Re: PLANNING EXTENSION TO 21 LENNOX STREET
ADC PLANNING REFERENCE BR/294/17/PL

I am writing to lodge my objection to the above extension to 21 Lennox Street. My reasons for doing so are:-

PROPOSED SINGLE STOREY EXTENSION AT 21, LENNOX STREET, BOGNOR REGIS
FOR MR. C. PATEL.

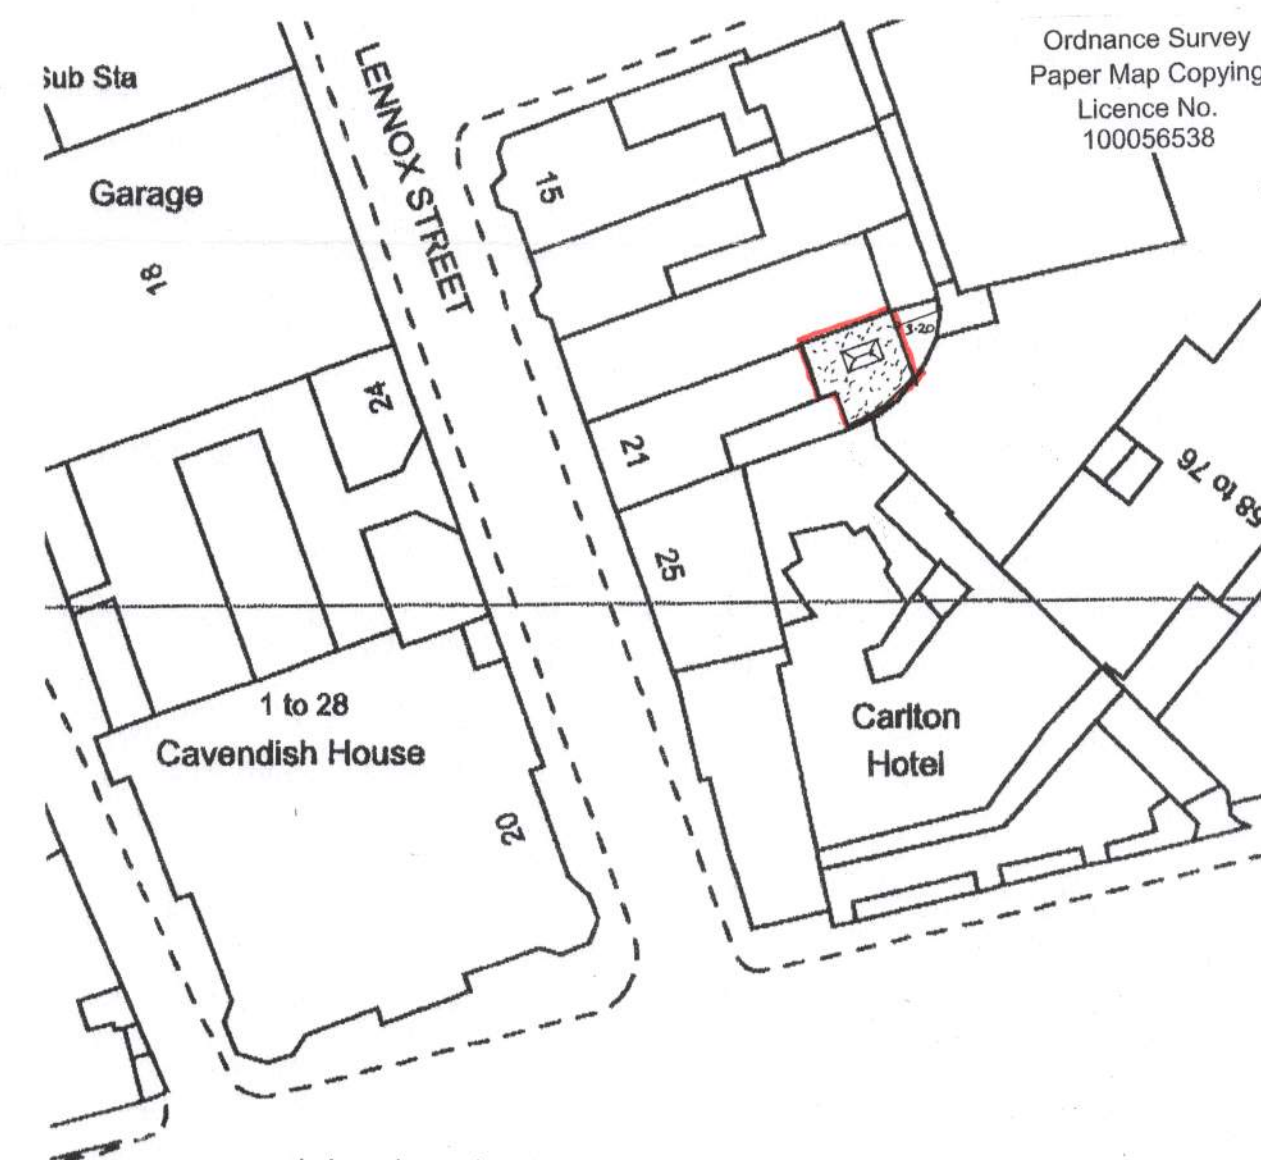
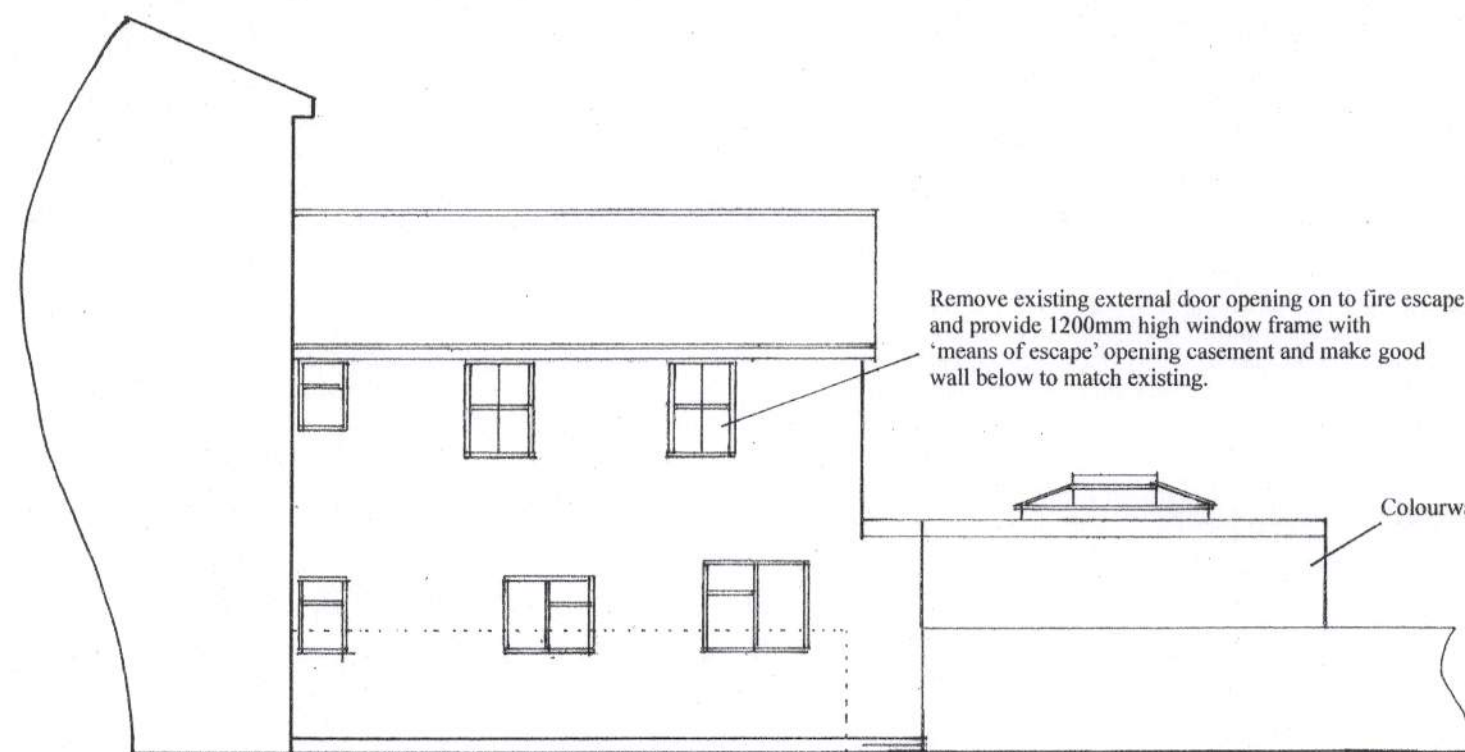
1. The building will be much higher than the existing party wall and block light.
2. Our adjacent existing brick built waste and recycling bin storage area next to the party wall will be very close to the new building and will likely be identified as a fire risk on our next fire risk assessment. We have no other area to relocate the bins, we are desperately short of parking spaces for the residents of D.Block.and could not afford to surrender even one.

3. The windows at the back of the proposed extension will overlook the party wall and will cause intrusion of privacy to the ground floor and first floor flat bedroom windows at the back of Block D.
